Re: Planning Application 20/1001

Address: 3 Portfield Bar Whalley BB7 9DL

Description: Erection of two storey extension and single storey extension to the rear.

Proposed Site Plan (1:200). 3 Portfield Bar, Whalley.

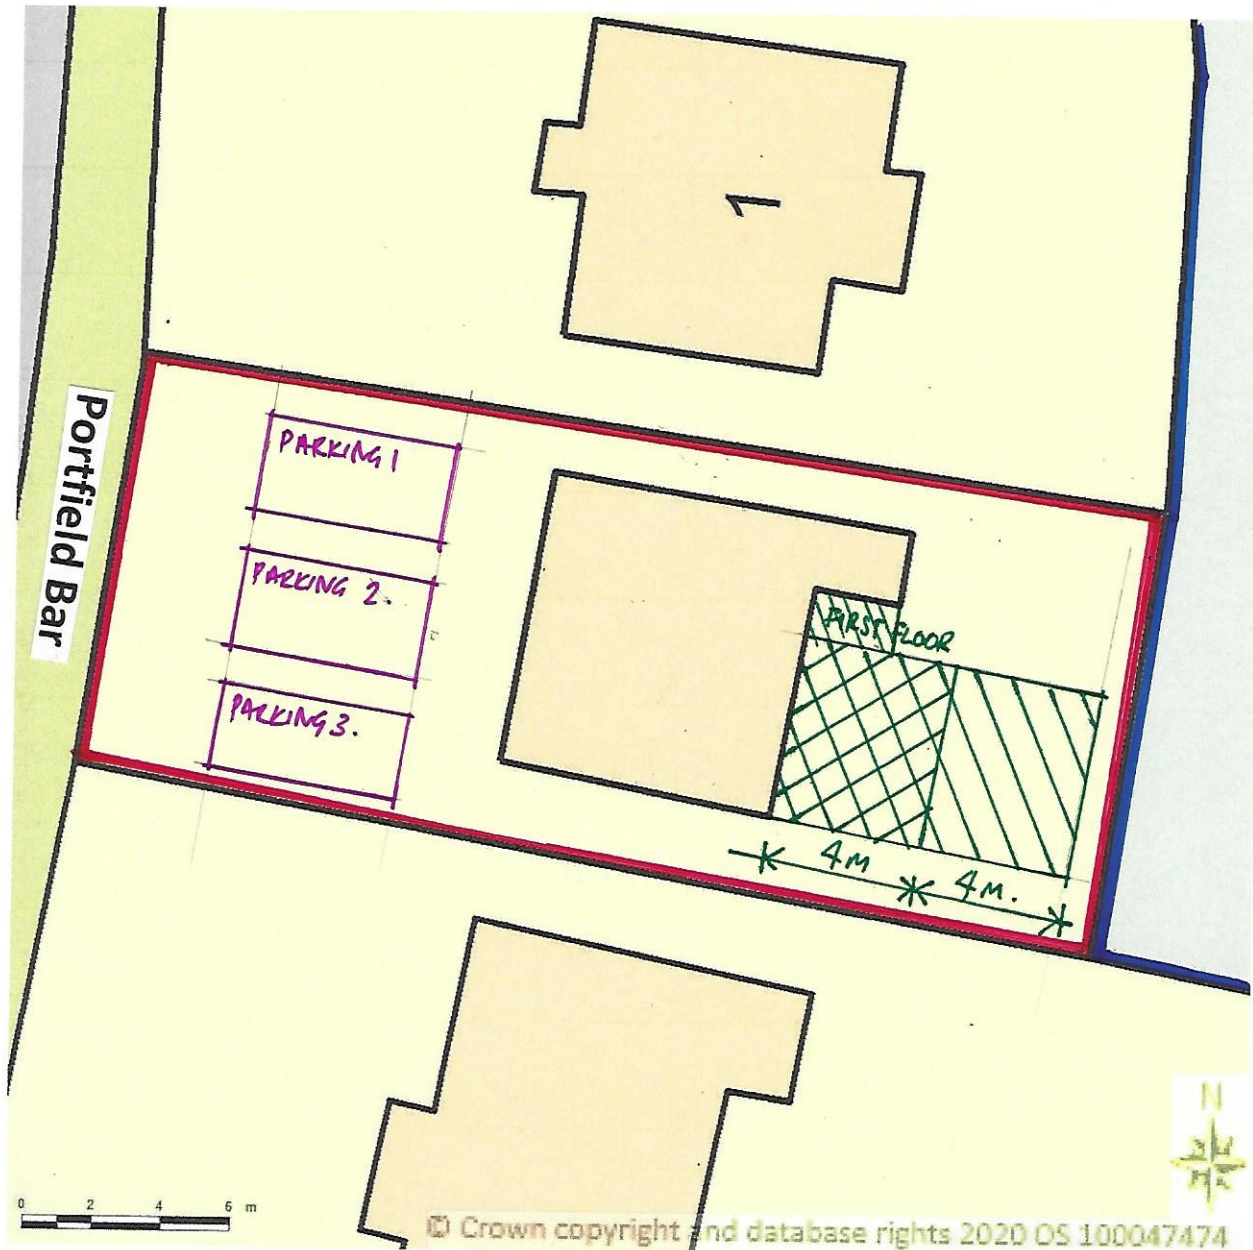
With respect to this application we would not raise any objections to the principle of the application. However there are a number of concerns regarding the off street parking.

In order to fully support the application we would look for a plan showing how the 3 off street parking places can be accessed from the highway. It is noted that the A680 Accrington Road, Whalley is a classified road, therefore it is expected that the off street parking shall be entered and exited in a forward gear.

1. Provision to leave in forward gear.

The layout of the development shall include provisions to enable vehicles to enter and leave the highway in forward gear and such provisions shall be laid out in accordance with the approved plan and the vehicular turning space shall be laid out and be available for use before the development is brought into use and maintained thereafter.

3. Car Parking.

No building or use hereby permitted shall be occupied or the use commenced until the car parking area has been surfaced or paved in accordance with a scheme to be approved by the Local Planning Authority. The car parking area shall thereafter be kept free of obstruction and available for the parking cars at all times.
